**WEST SUSSEX COUNTY COUNCIL
INFRASTRUCTURE CONSULTATION**

**FROM: Ian Gledhill TO: Arun District Council
FAO: Anita Gardner**

**SUBJECT: R/61/09/ - COU from class C2 (res institutional) to class C3 (dwellings) -
amendment to prev. apr. R/163/08**

**West Preston Manor Bungalows, Pigeonhouse Lane, Preston Paddock,
Rustington, West Sussex**

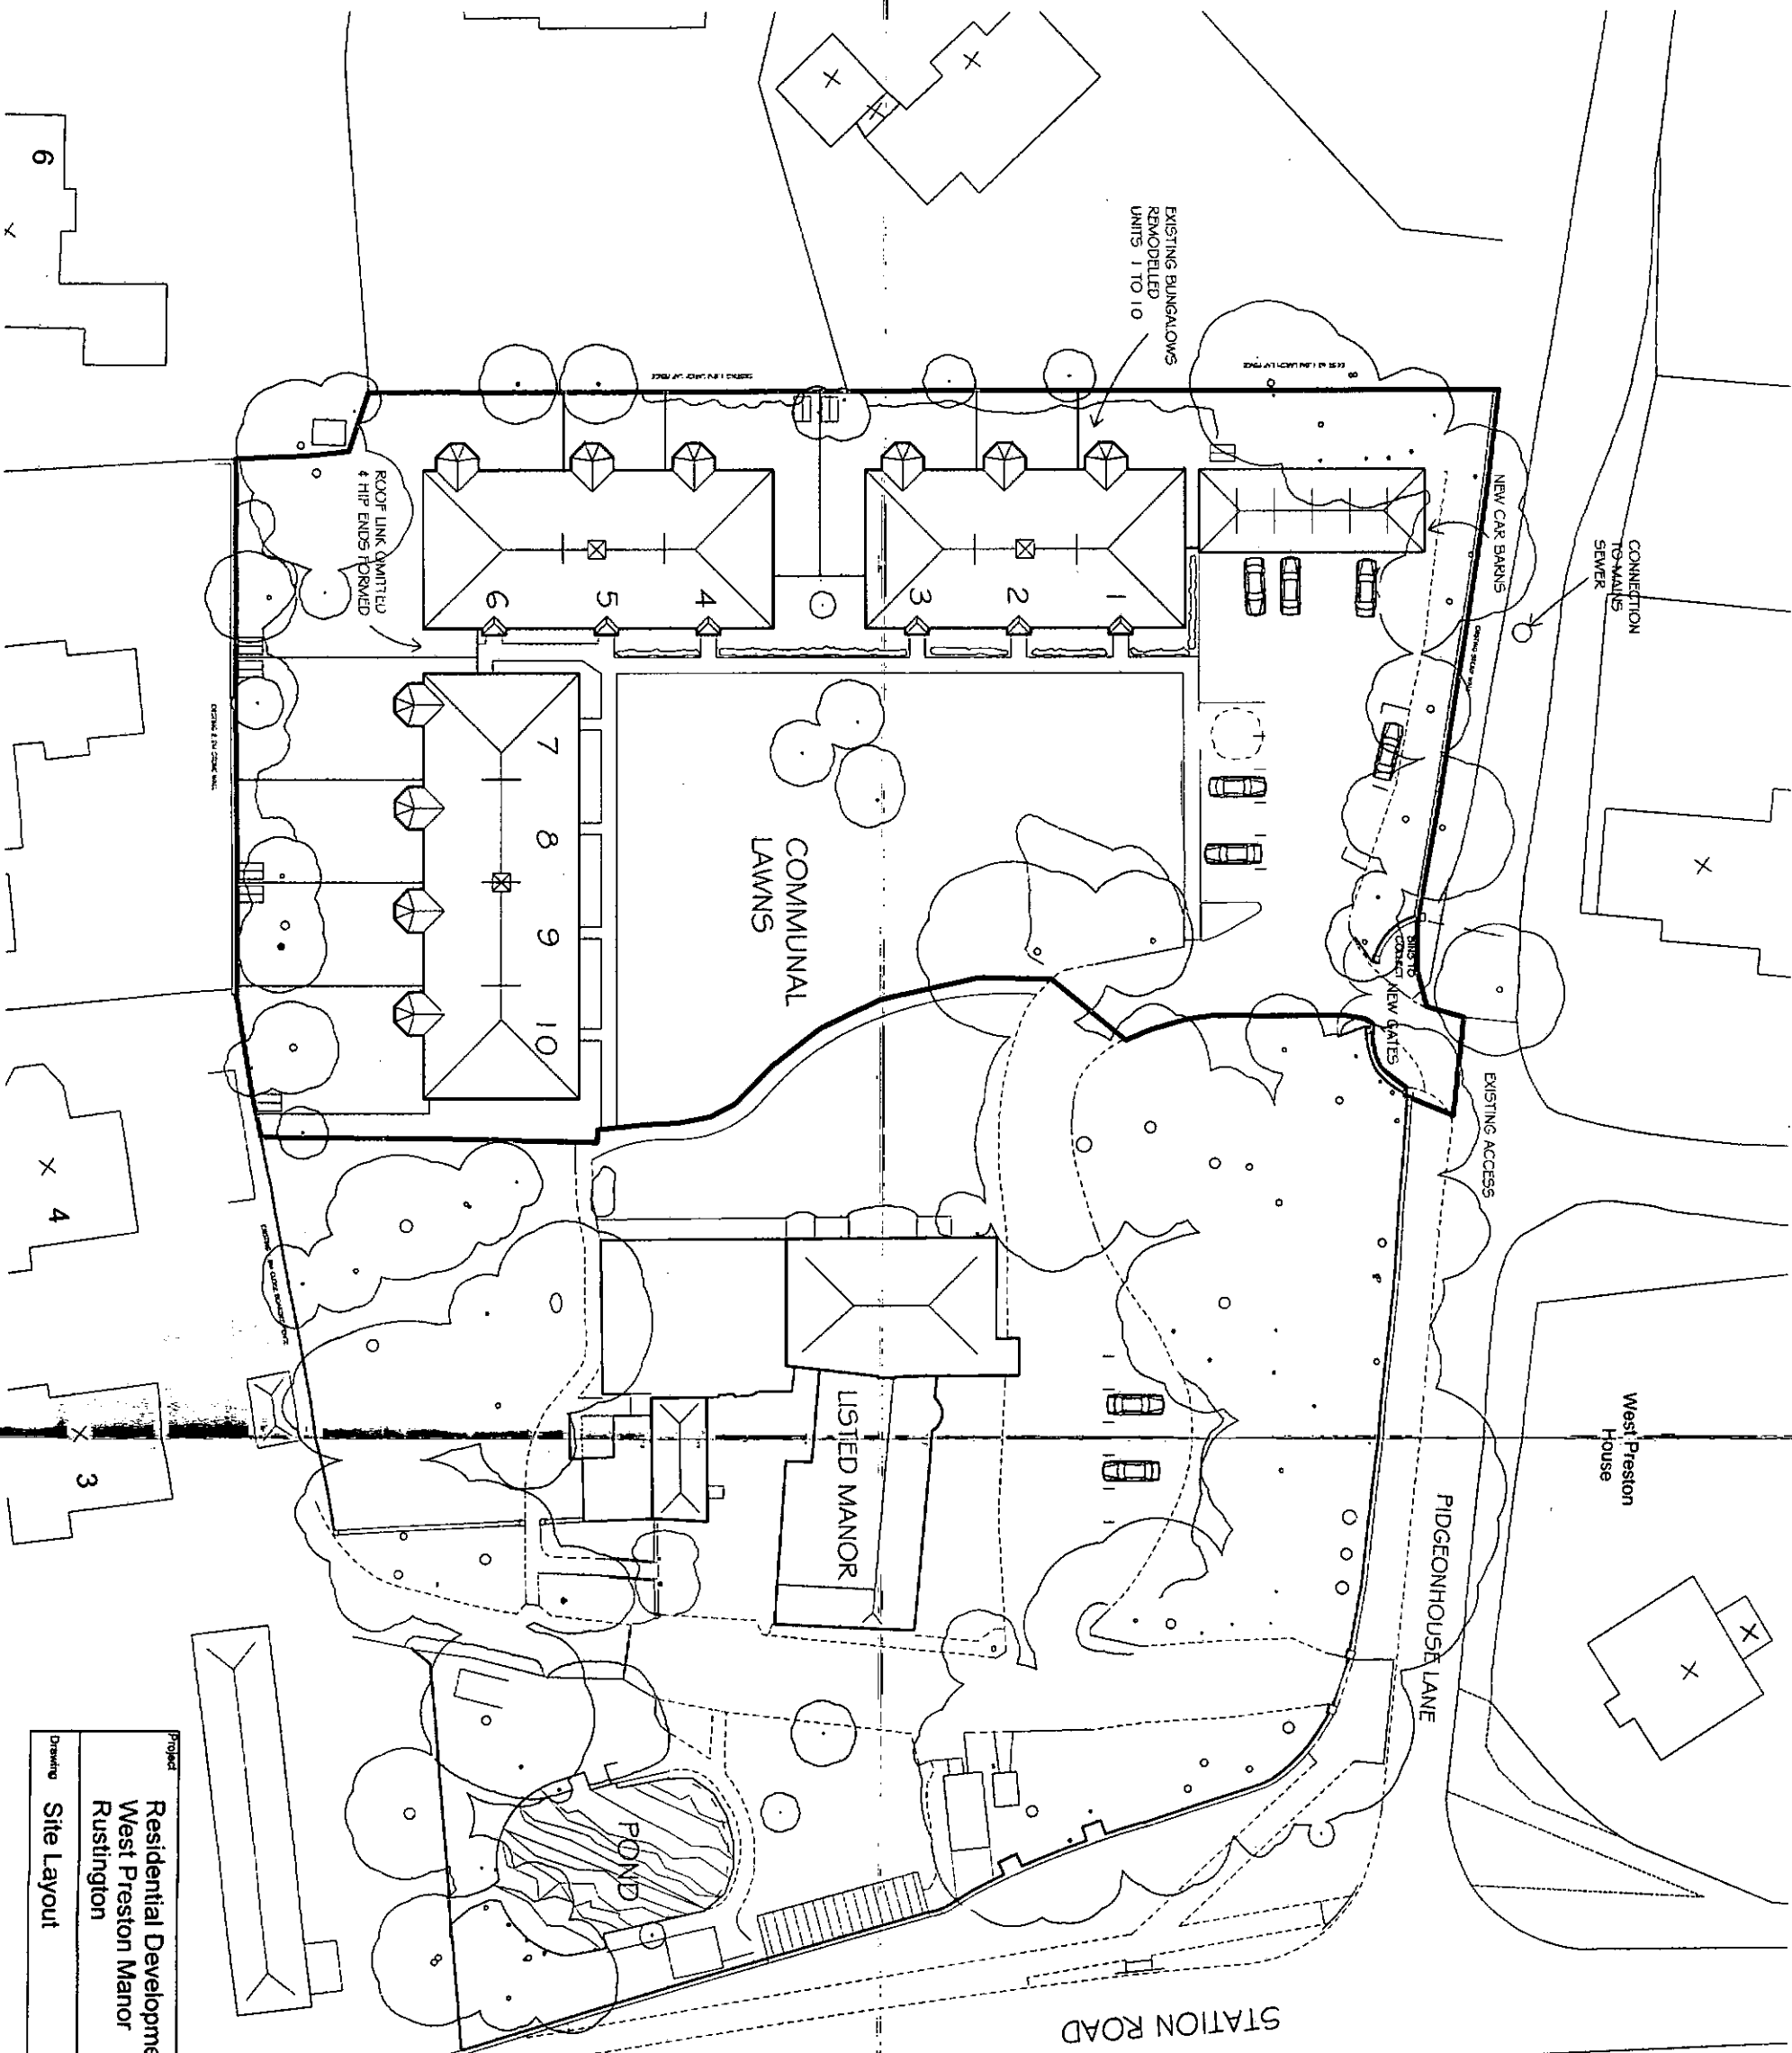
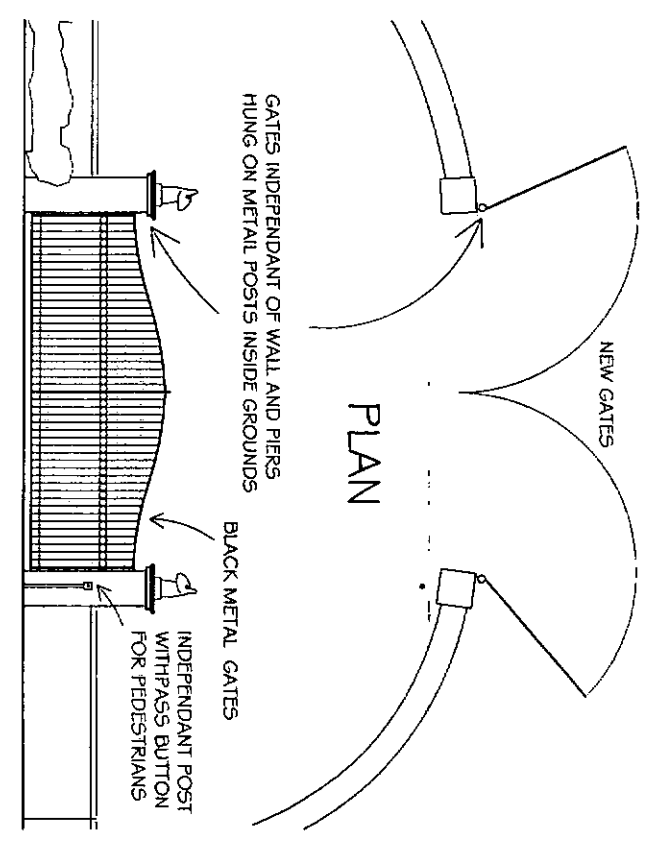
Whilst no physical alterations are proposed to the access, access gates are also now proposed. The provision and location of the gates would not cause raise any concerns.

Details of the cycle parking facilities should be secured via condition.

The dwellings hereby approved shall not be occupied until such time as the details of the cycle store have been submitted to and approved in writing by the Local Planning Authority. The facility shall thereafter be provided and retained for such use. REASON: To encourage the use of cycling in accordance with policy DEV 4 of the WSCC Structure Plan and GEN15 of the Arun Local Plan.
